Whether the removal of 3 no. (high/eaves level) refrigeration units to the eastern elevation, and the installation of 1 no. Dry Cooler unit within the Loading bay area, The erection of green mesh fence surrounding Dry Cooler unit within the Loading Bay Area, The removal of green mesh fence surrounding Dry Cooler unit within the Loading Bay area, The installation of 4 no. (low/ground level) Air Conditioning units to the Northern Elevation, The removal and relocation of 4 no. (low/ground level) Air conditioning units to within the Loading Bay Area, The provision of a fifth (low/ground level) Air conditioning unit to within the Loading Bay Area, The installation of 2 no. (low/ground level) air conditioning units to the Eastern elevation, The provision of a screen/enclosure surrounding proposed air conditioning units and existing dry cooler refrigeration unit

Lidl, Johnswell Road, Kilkenny.

DEC 739

Peter Nelson

Figure 1: Proposed Location of Air Conditioning Units (Outlined in Red)

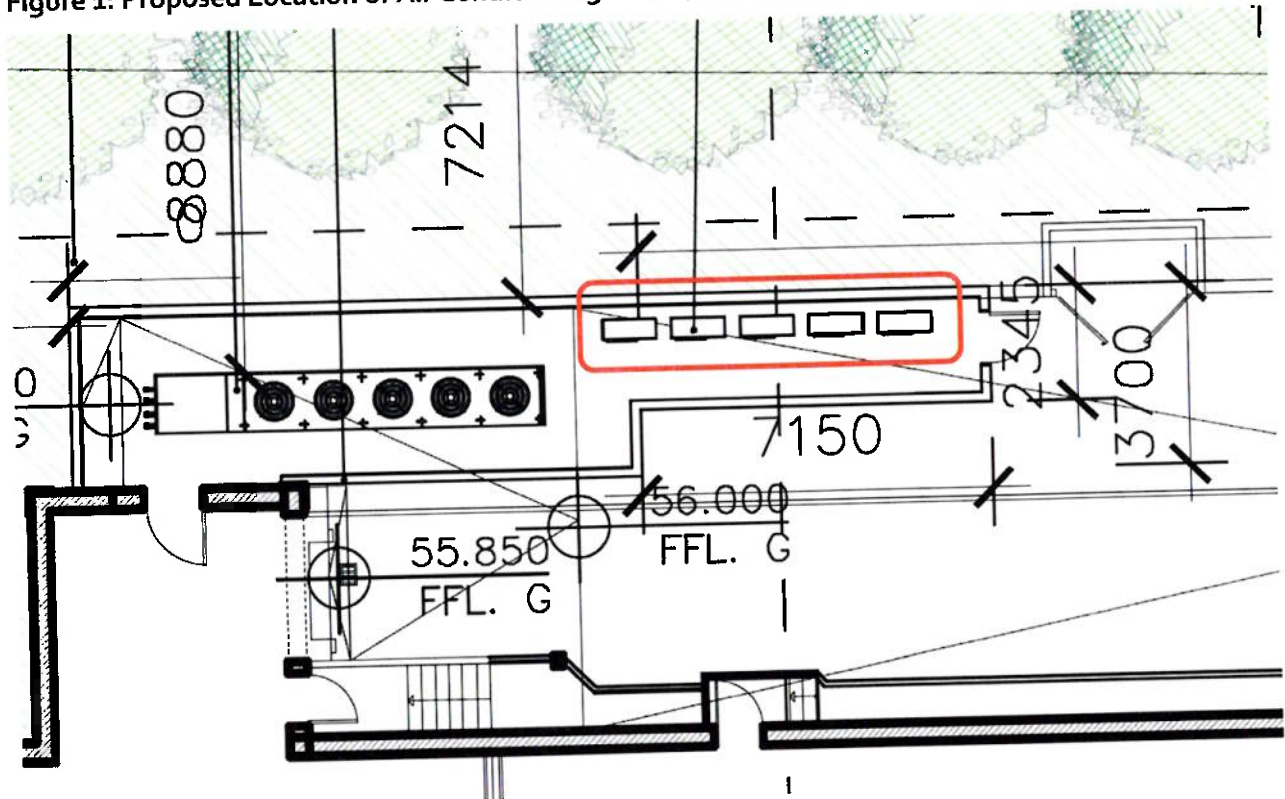
I consider that the proposed installation of the 6no. low-level air-conditioning units and the dry cooler, due to their location and number, will be inconsistent with the character of the open amenity space and residential area which are directly adjoining the subject structure.

8.4.11. Having regard to the above I consider that the proposed installation of the 6no. low-level air-conditioning units and the dry cooler are not exempted development.

Figure 4: Plan View

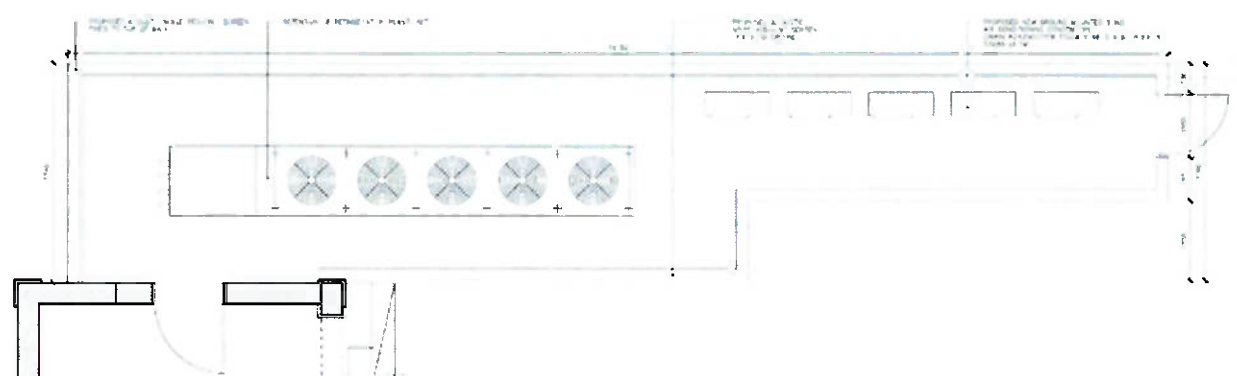
The proposed screen/enclosure surrounding the dry cooler unit within the loading bay area, as shown on the drawing submitted with the referral, has a height of 2m. I therefore considered that the proposed fence is exempted development.

Figure 5: Landscaping

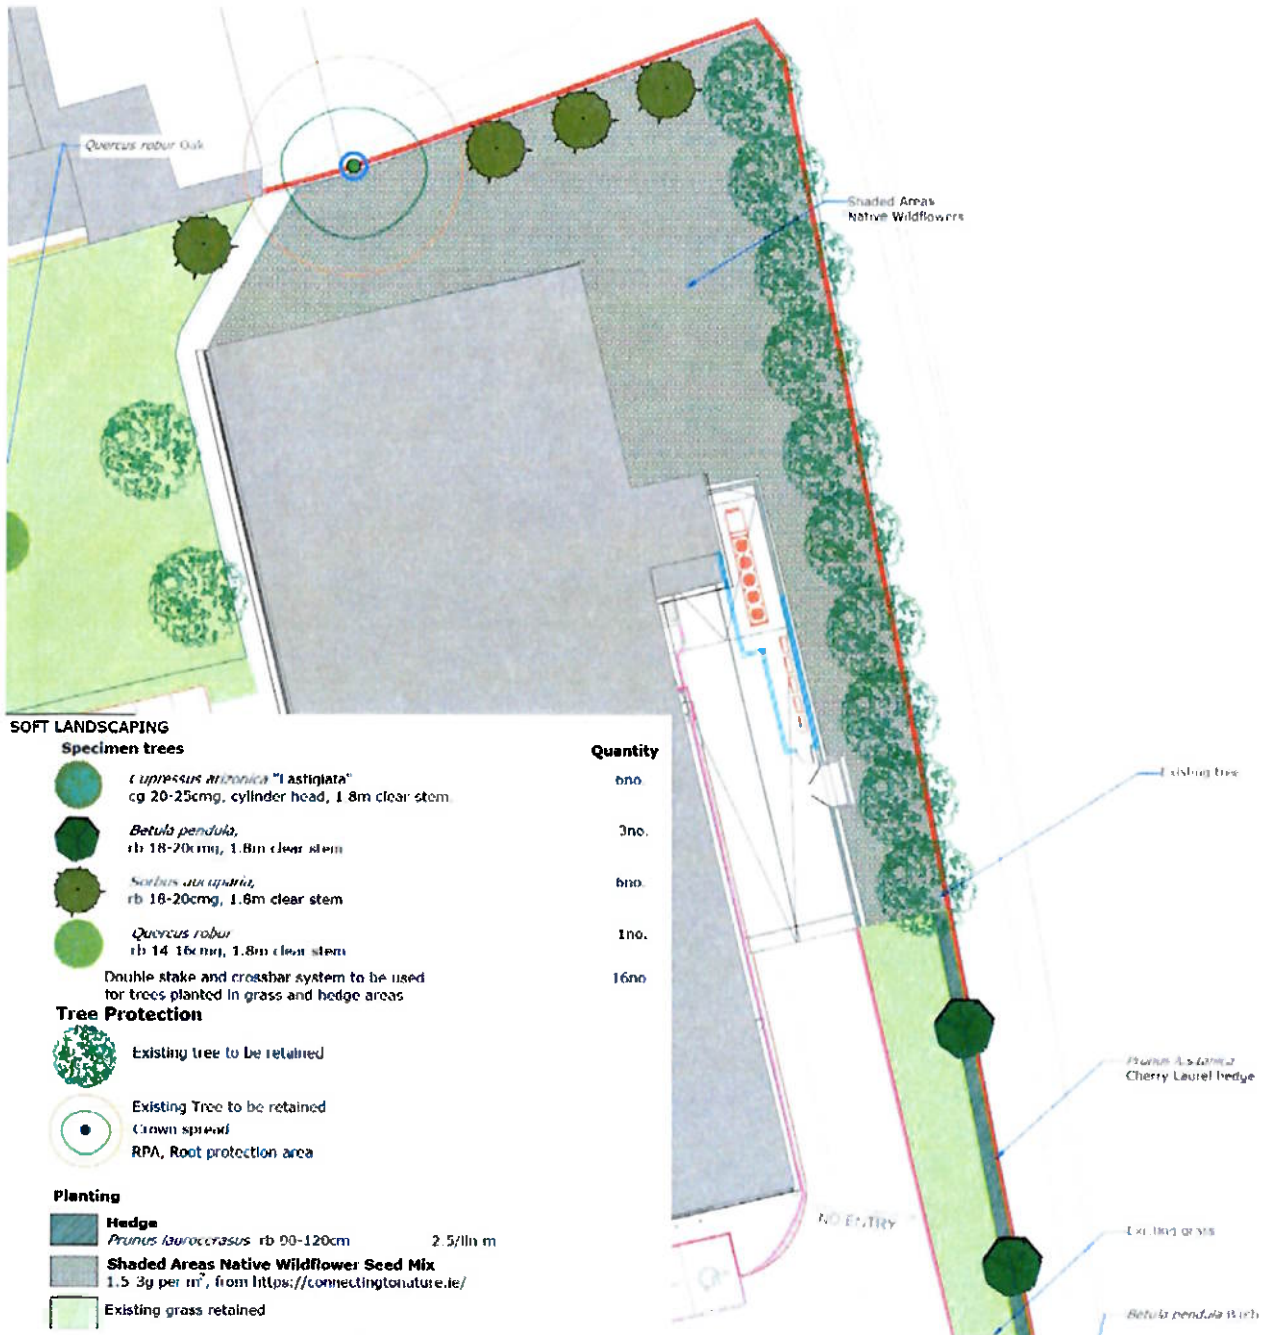
8.4.13. Fourthly, I will consider whether the proposed landscaping works are exempt from development. The referrer has submitted a landscaping scheme. The question the referrer asks is if the landscaping and all associated and ancillary works and development are exempted development under Section 4(1)(h). As the associated and ancillary works and development have not been specified, I will only consider the question as it relates to the landscaping scheme. The scheme consists of wildflower planting and four additional trees.

- 8.4.19. I do not consider that the proposed landscaping scheme materially affects the external appearance of the structure so as to render the appearance inconsistent with the character of the structure or of neighbouring structures. The proposed landscaping will assimilate into the surrounding parkland.

- 8.4.20. Having regard to the above I consider that the landscaping scheme is exempted development.
